Our Ref: 70058541  
28 February 2020

**Great Wolf Resort, Bicester: WSP Responses to comments from CDC Ecology Officer 05 February 2020**

The following outlines our response to the comments provided in correspondence of 28th January 2020 by Dr Charlotte Watkins (Cherwell District Council's Ecology Officer) to Clare Whitehead, regarding the application 19/02550/F for the Land to the East of M40 and South of A4095, Chesterton, Bicester.

**Figure 4 – Phase 1 Habitat Survey Results**

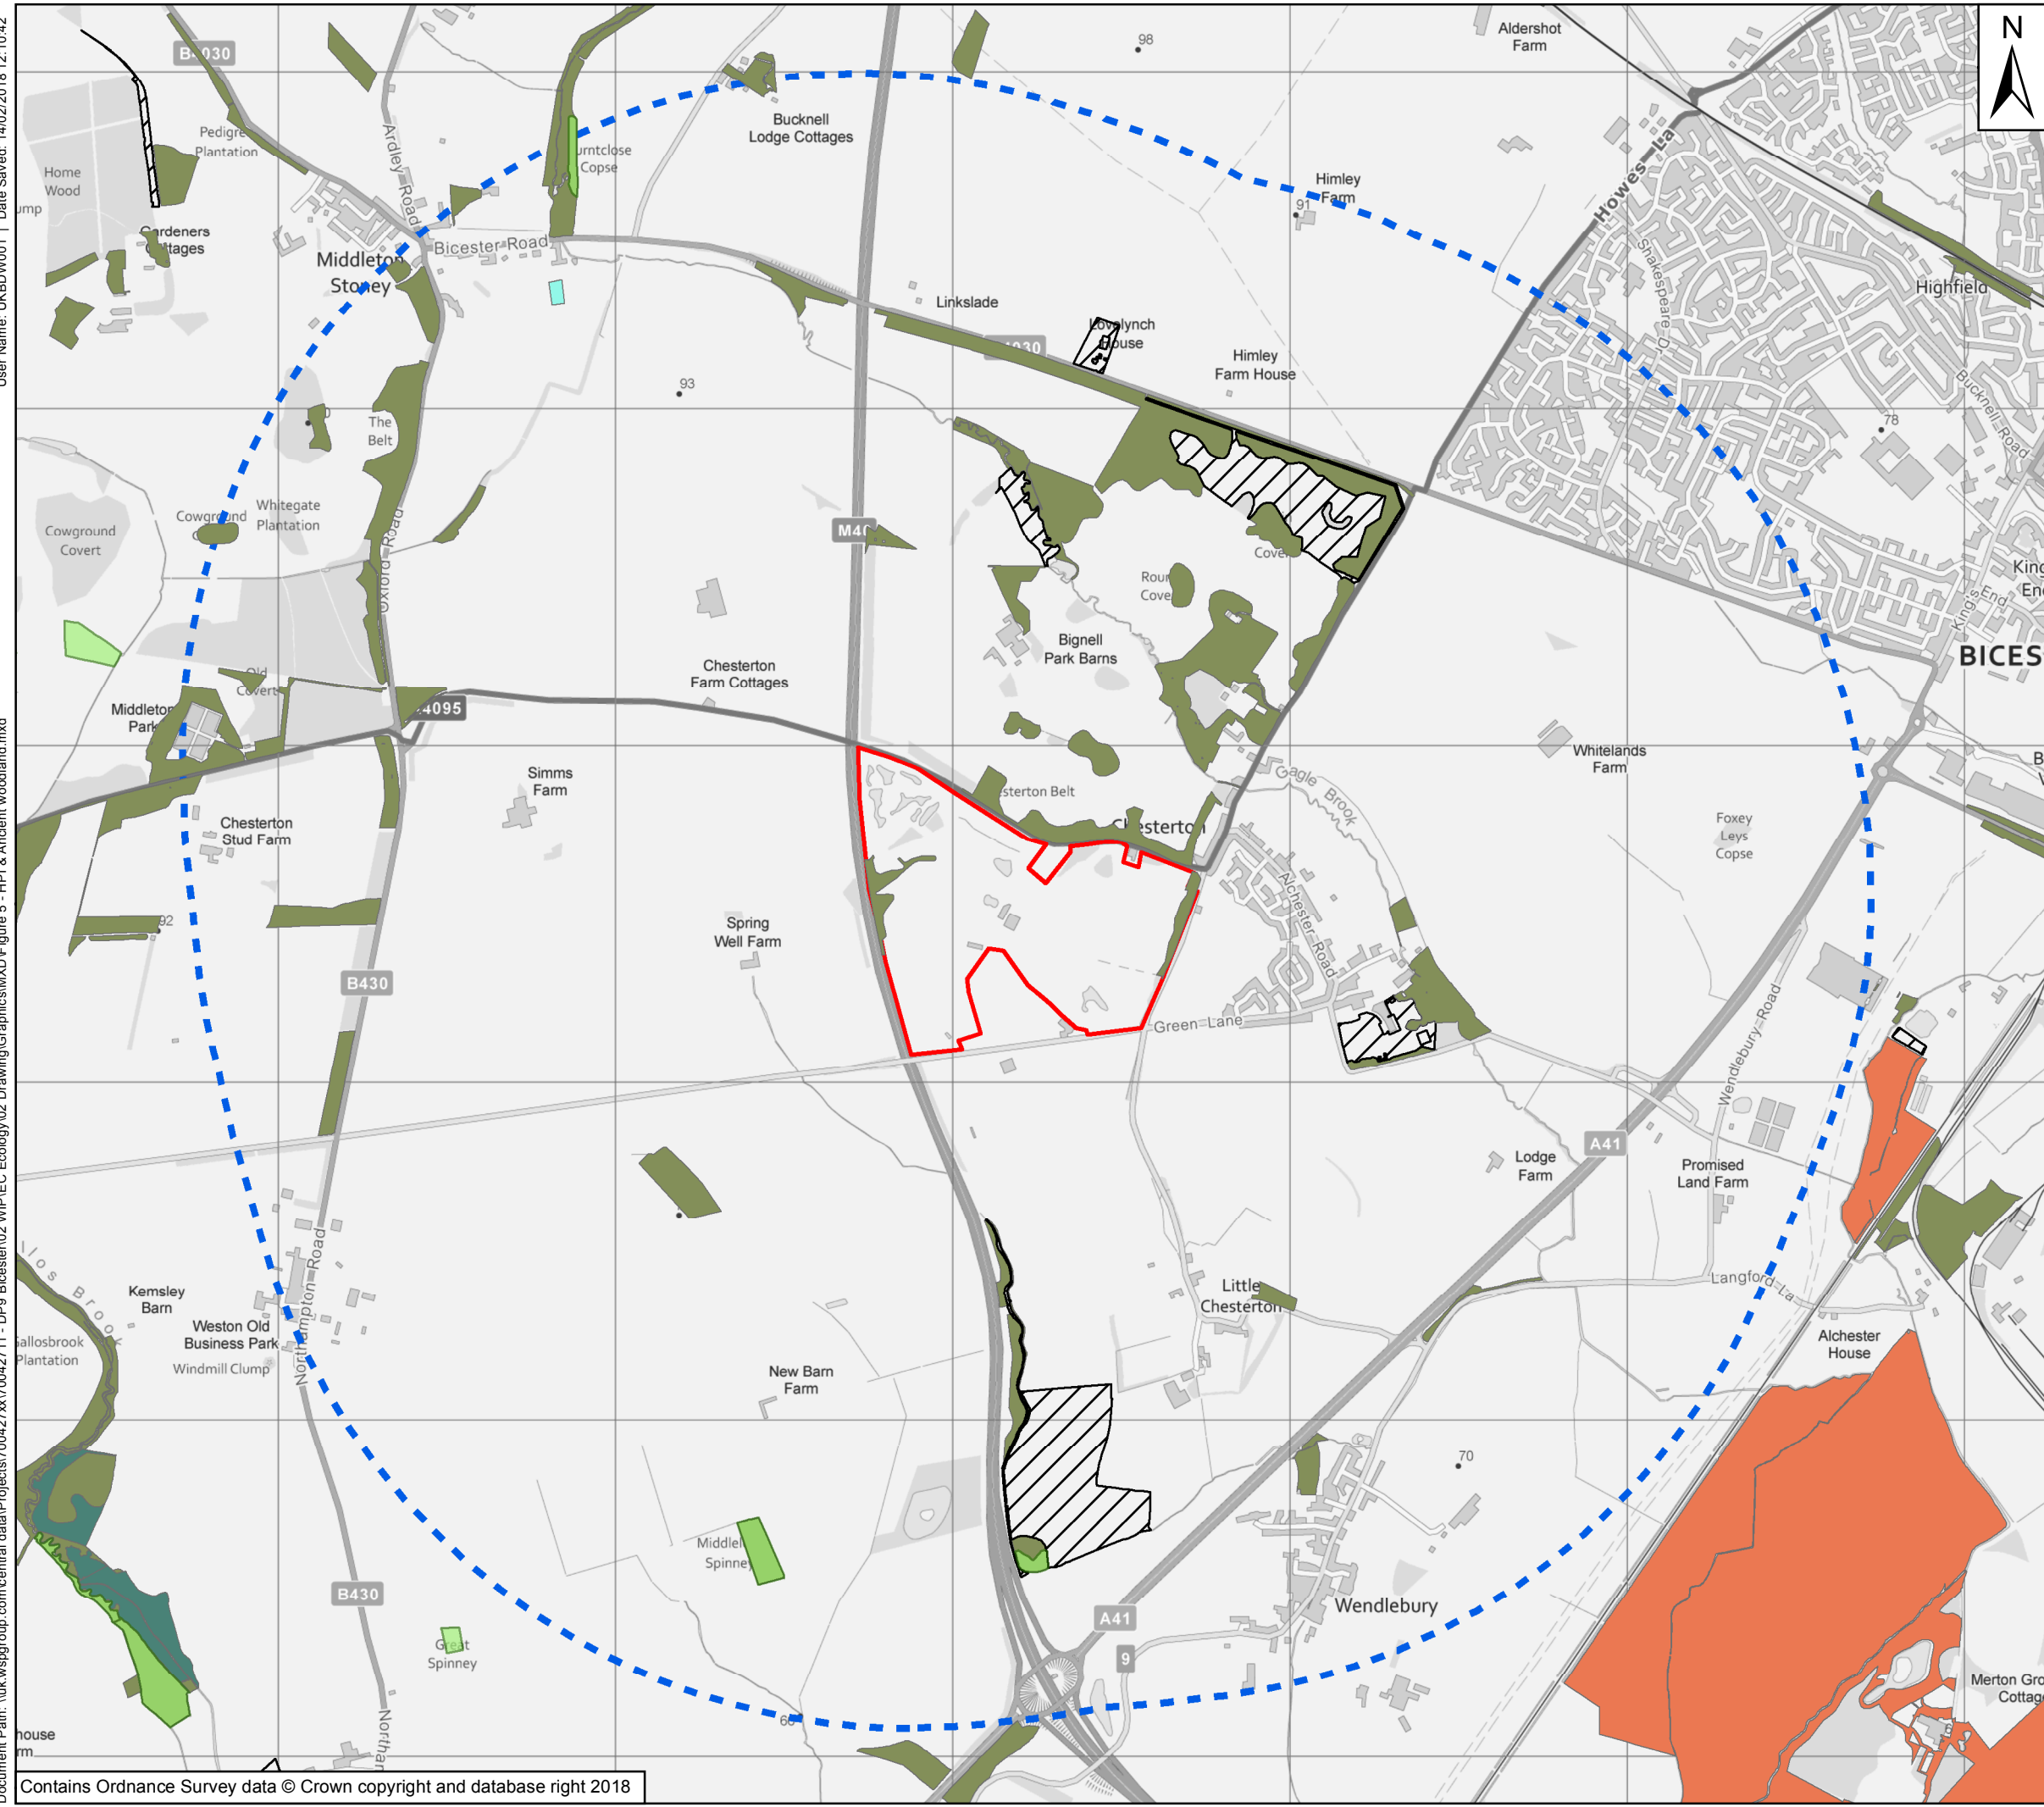
<u>CDC Ecology Officer Comment</u>	<u>WSP Response</u>
<p>...and there is some loss of important habitats long term, namely running water. The net gain calculation summary states these are ditches which are often dry and will be replaced by swales however the Phase 1 survey report states there is a small stream (RW1) which looks to also be being lost and I wonder if this is accounted for? I couldn't find anything else on this.</p>	<p>One of the ditches on site was classified as running water in the Phase 1 habitat survey. This survey was conducted in January 2018, and at that time it was holding some water. However, on subsequent visits it was dry and therefore can be classified to be a dry ditch. This is a man-made feature lacking in semi-natural attributes which would not support a significant assemblage of aquatic specialist species. Accordingly, it is appropriate that it can be compensated for by the provision of swales.</p> <p>Further evidence to support this conclusion is provided by the drainage strategy (prepared by <i>Curtins</i>), which has been discussed with Oxford County Council as the Lead Local Flood Authority, identifying the stream as a ditch '<i>Ditch 2... which discharges into an irrigation pond</i>'. Appendix 8 of the Drainage strategy provides further information regarding the ditch: '<i>As shown above, there are two existing ditches running across the Site from north to south. It is understood that these ditches were constructed by site maintenance staff to manage ground water. This was confirmed by the site staff during a walkover. The two ditches join in an inspection chamber to the north of the existing hotel</i>'. Photographs of the ditch are enclosed as further evidence.</p>
